HASKONING AUSTRALIA PTY LTD.

**Bank Street, Pyrmont - Navigation Impact Assessment
Response to Submission and Preferred Project Report Response**

Following closure of the exhibition period for the Response to Submission and Preferred Project Report, several matters were identified in relation to the Navigation Impact Assessment (NIA) report (Revision 4.0, dated 17 November 2017) prepared by Haskoning Australia.

BANK ST, PYRMONT NAVIGATION
IMPACT ASSESSMENT
PROPOSED MARINA BERTHING PLAN
MAP 5

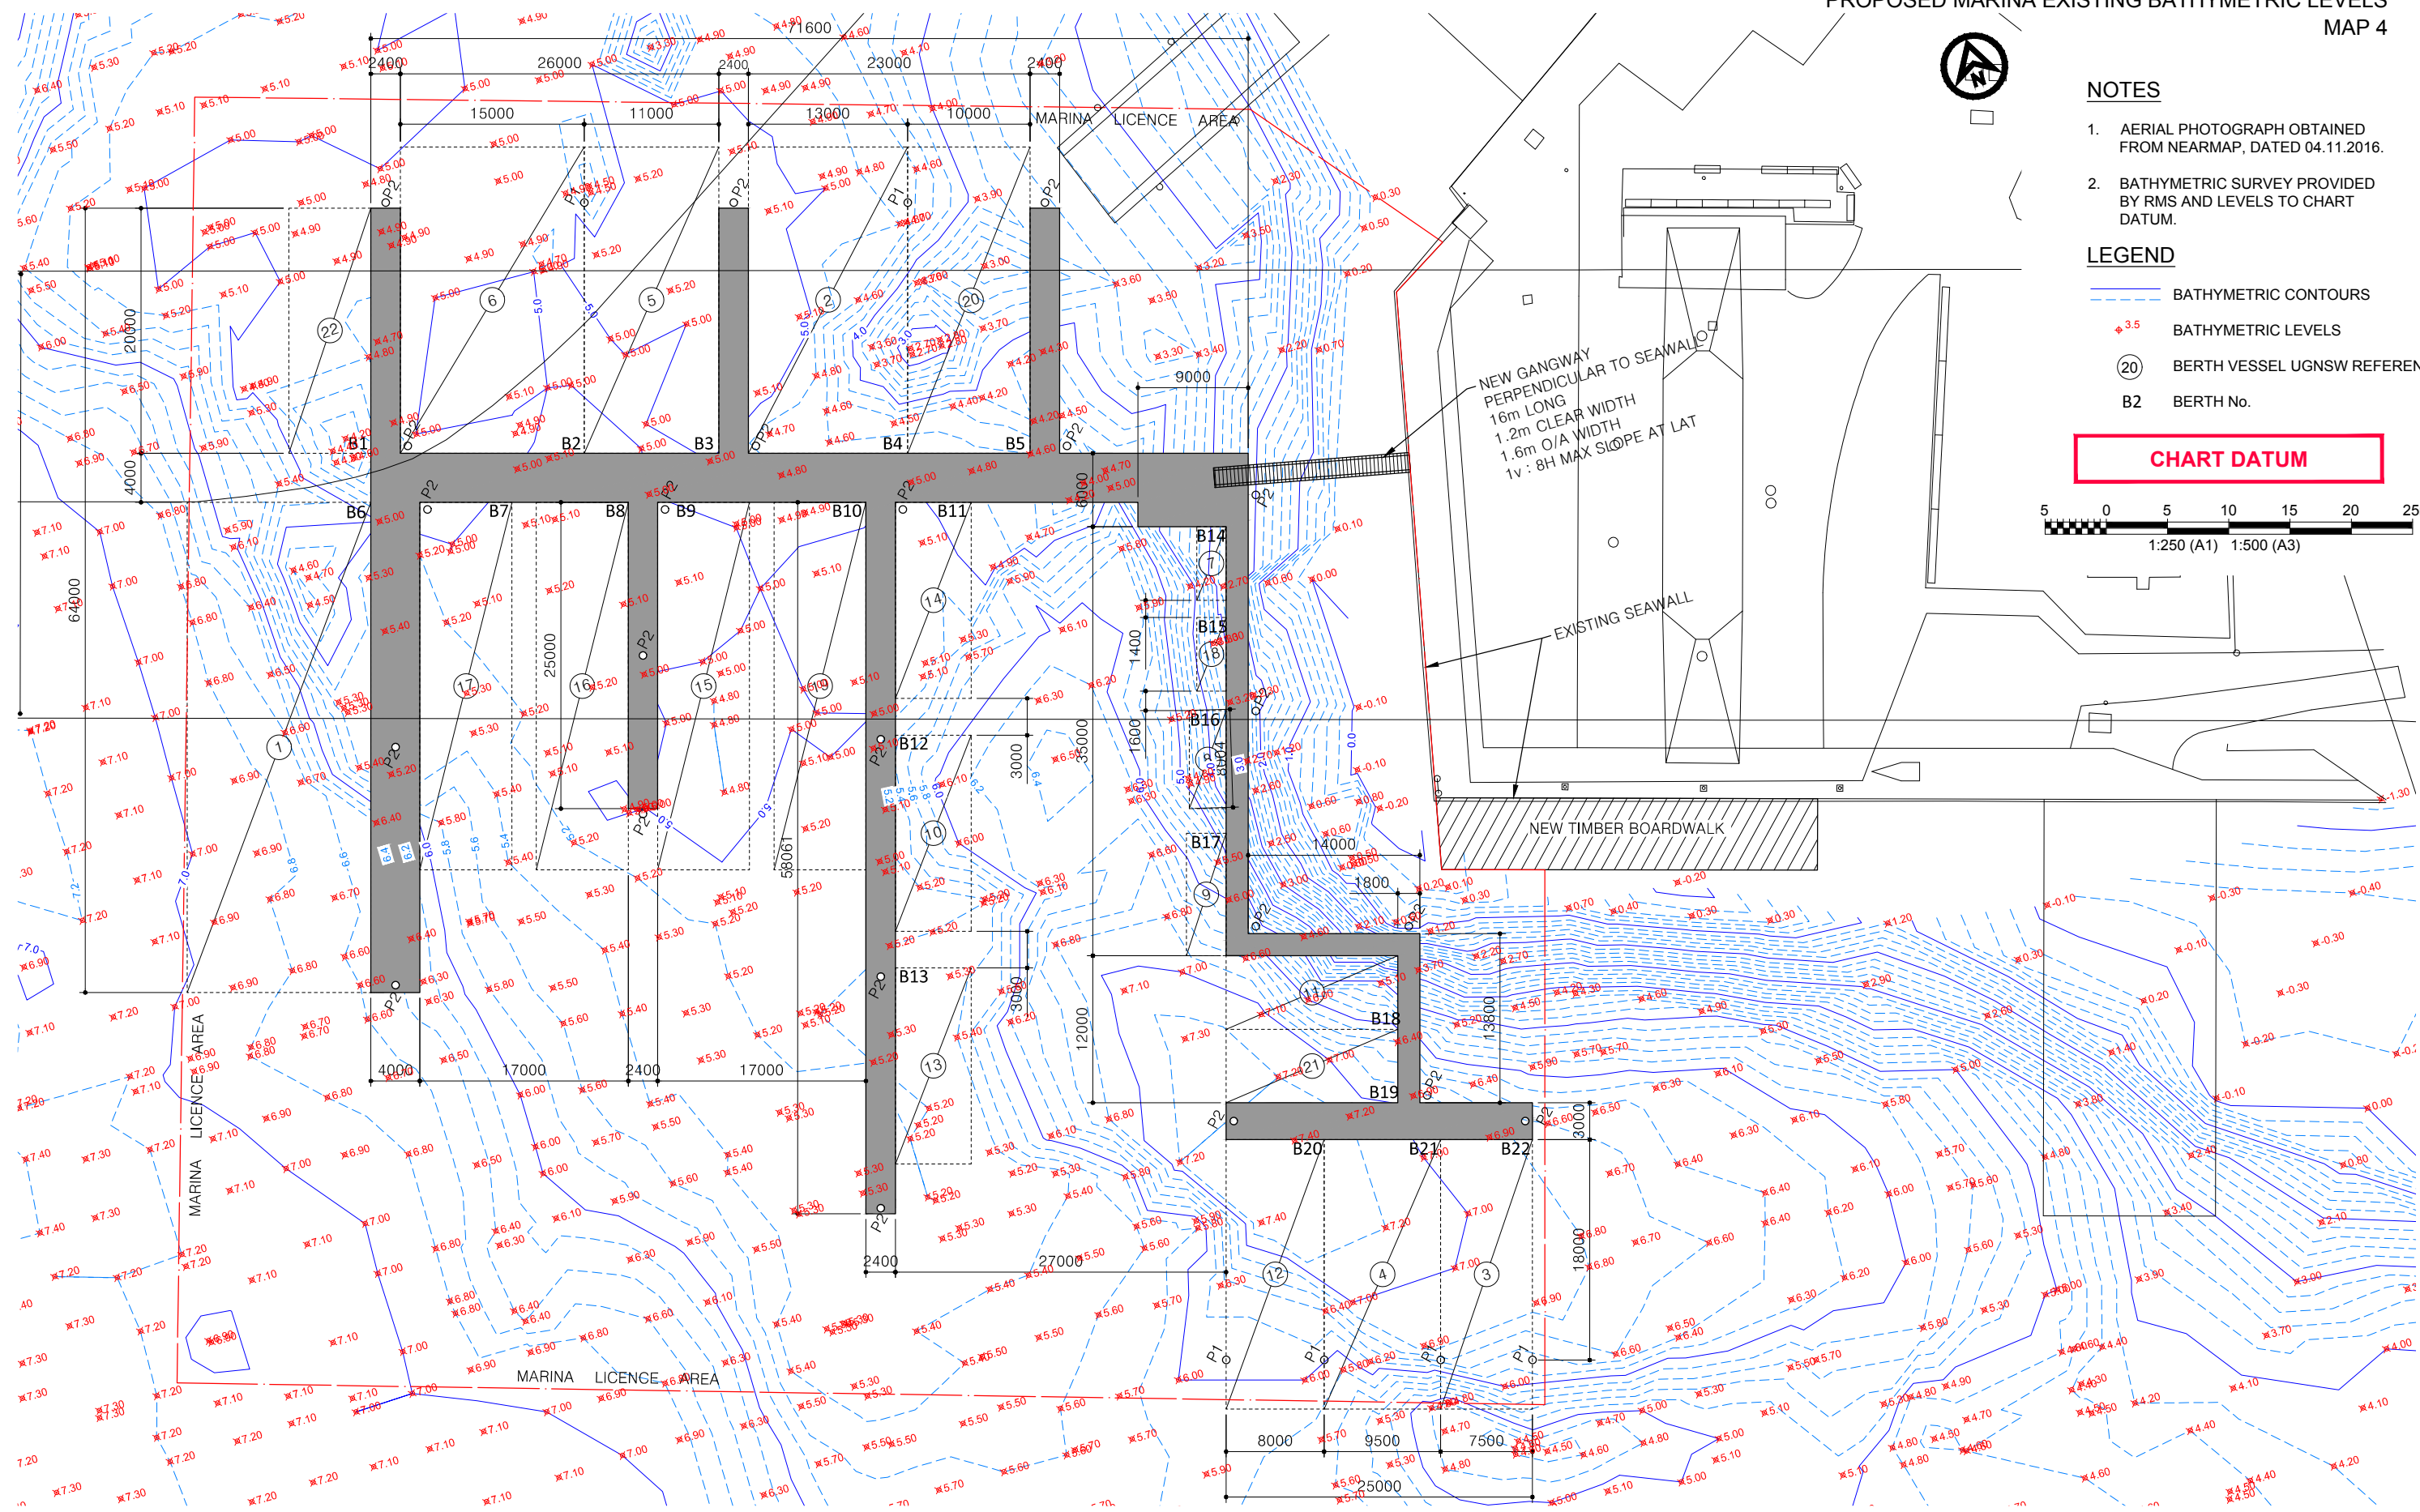
2. *Confirm the proposed berthing location of the "Southern Star" and "Sunseeker" vessels in light of the statement in the Navigational Impact Assessment that the wave climate experienced at the marina site complies with guidance for acceptable conditions within AS3962-2001 (Guidelines for Design of Marinas) subject to the berthing location of these vessels.*

We confirm that the proposed berthing plan is shown on Map 5 within the NIA and includes substitution of the 'Sunseeker' with the 'Southern Star' for compliance with AS3962-2001.
